34 Howard St - survey question

Thank you for sending the additional requested information. I have one last question before I can sign off for zoning compliance. I noticed that the deed description for the lot and the surveyed boundaries of the lot are slightly different. The deed description describes the lot as a 40' square, but the surveyed boundaries vary a bit from that. I am guessing this is the result of the simple fact that this land was surveyed many years ago, before modern techniques existed. But it would be helpful to get an opinion from your surveyor about the discrepancy and whether there is any way to resolve it, such as by revising the deed description. Could you get in touch with your surveying company and ask if they could send me any info and opinion they can on the

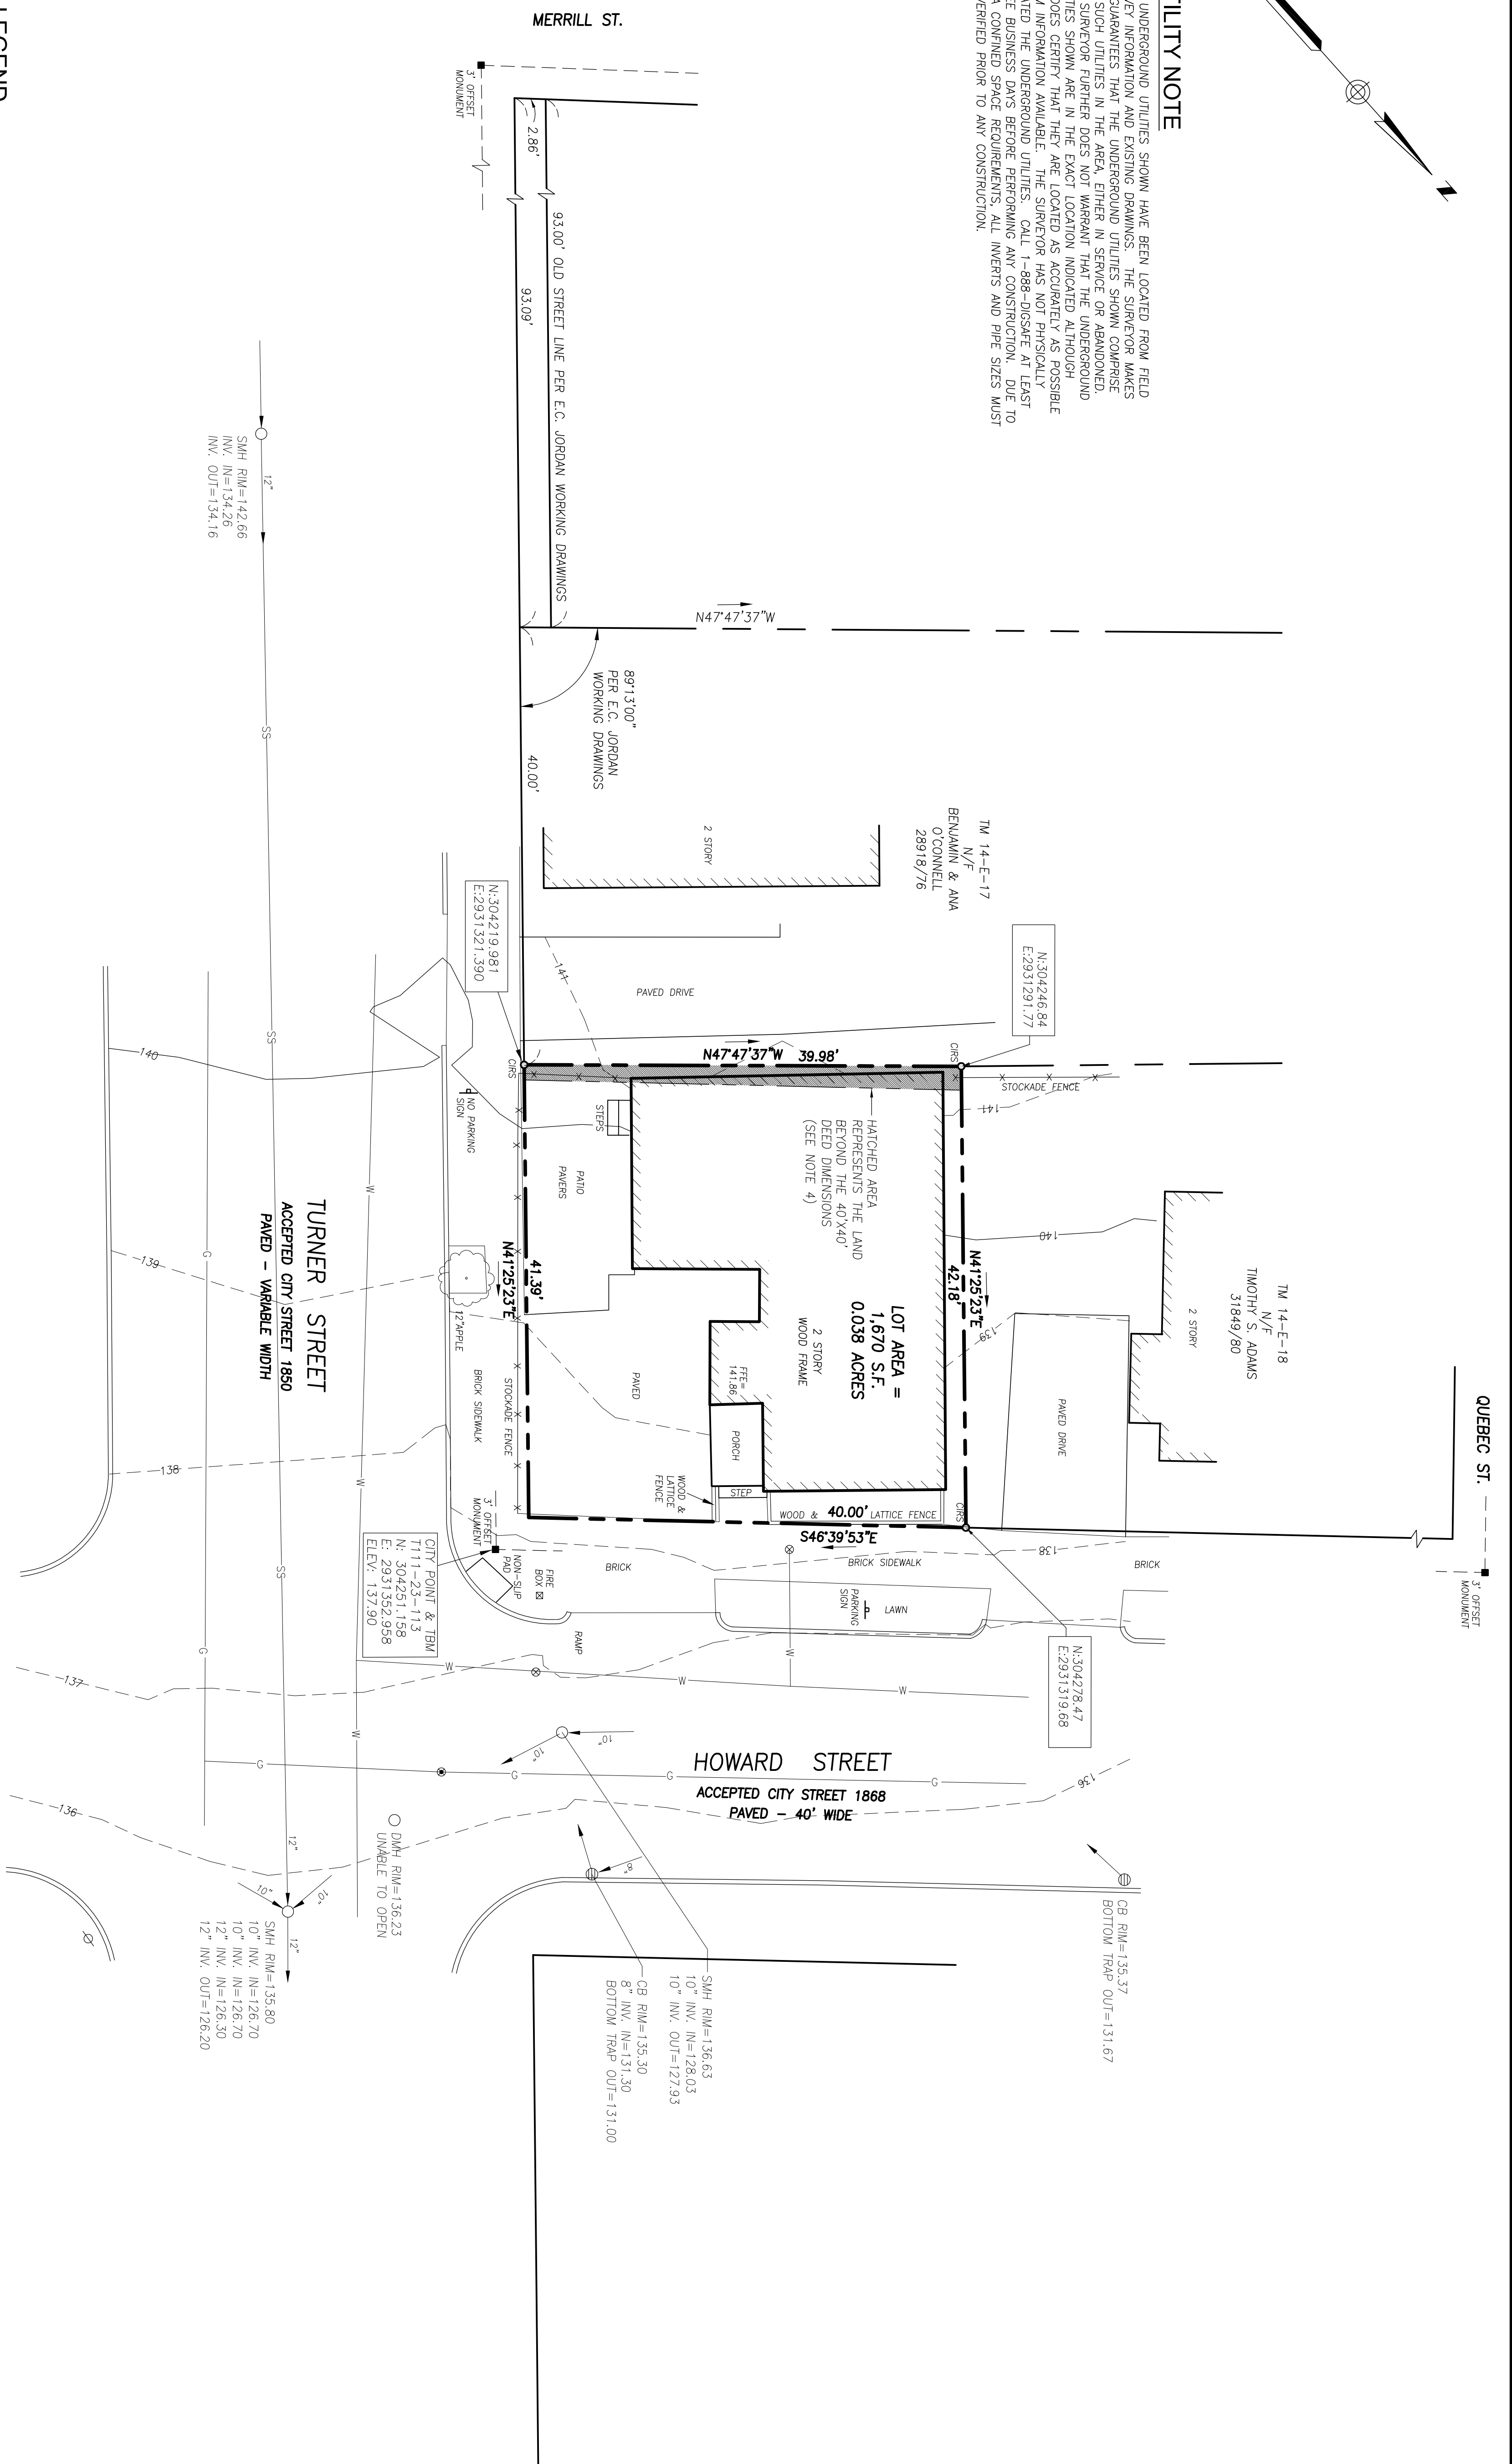
discrepancy?

The attached survey highlights the area in question (app. 2' to the south side of the property).

Our client has a perfectly good, current survey of their property. Because the deed has a 40' call in it along Turner Street someone totally ignored the rest of that call which calls for the abutter. By requiring our client to get a boundary agreement they are saying that the 40' (distance) holds over the call for the abutter (monument). That goes against all the rules of evidence which have been in place for ever. It would also cut off the corner of our client's house. By that reasoning if the abutter were only 38' from Howard Street not 42' would the Title Company still insure our client the full 40'?

Thanks, Randy. The good news is that the neighbor's property description is consistent with the conclusions that you and John reached about the correct description of Zane and Meredith's property, as depicted on the survey.

John, after a review of the earlier deeds and researching the case law, I agree with your view; if this issue comes up for you in the future, the Maine Supreme Court decision which is on point is Edmonds v. Becker, 434 A.2d 1012 (Me. 1981). The best way to describe this is that a call to the land of an adjacent owner is construed as a monument, and a monument takes priority over a conflicting distance call. For purposes of construction, when a call runs to adjacent land, the deed is interpreted to convey the entire parcel, and not that the grantor intended to retain title to a narrow strip of land.

Also, I'm glad to work with the City of Portland if necessary to address this if necessary. The City's tax maps show your property as 40 feet by forty feet, but if I'm using the correct scale on that plan, they get there by "rounding" to showing you and your neighbor as having a little more than 40 feet each, and the other two lots on that side of the street as having slightly more than 94 feet, rather than 93 feet; in fact, your property includes the "missing" 1.4 feet. (This is an excellent example of how tax maps lack the precision of a survey.)
